Subject: Riste Short Plat, SP-15-00007

Enclosed are the comments received regarding the Riste Short Plat (SP-15-00007):

SUBJECT: Riste Short Plat SP-15-0007

SCALE: 1"=300'
DATE: 12/15/2015
SHEET 1 OF 1

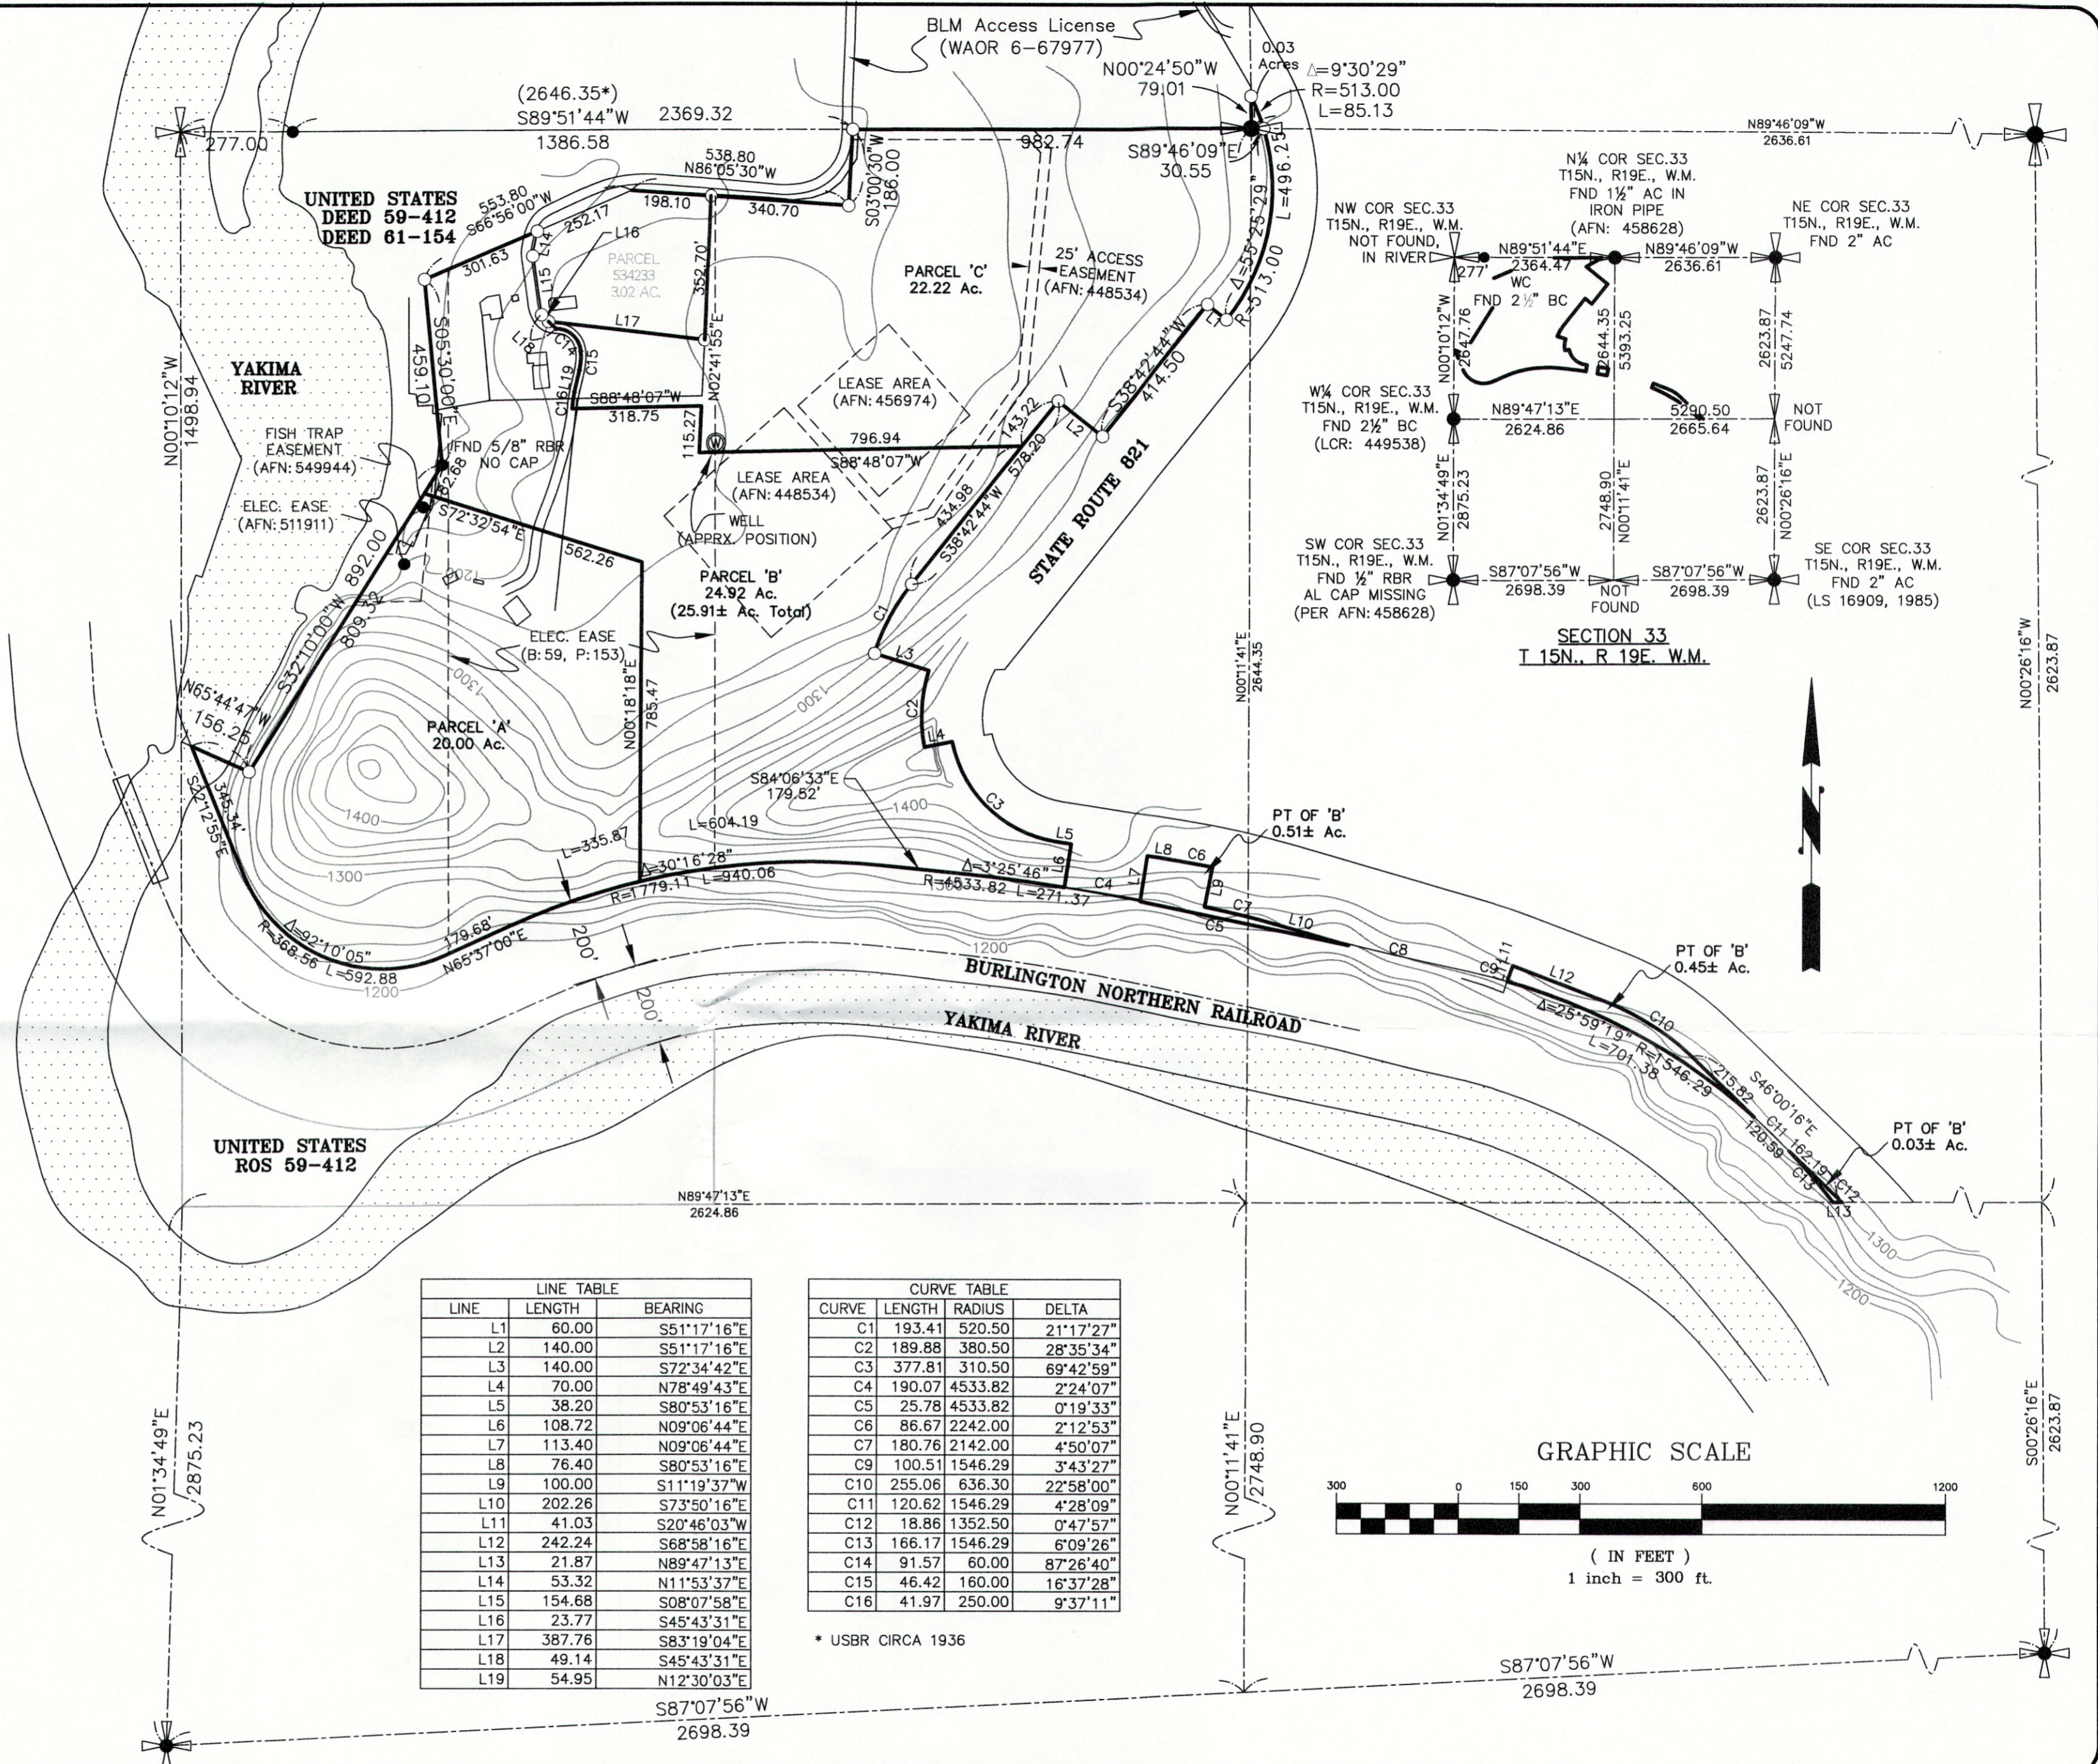
1. An access easement for Parcel "A" of the Riste Short Plat needs to be shown on the face of the short plat.
2. No driveway or road shall be constructed within five feet of the side yard boundary, unless the driveway or road is part of an easement shared with the neighboring property owner.
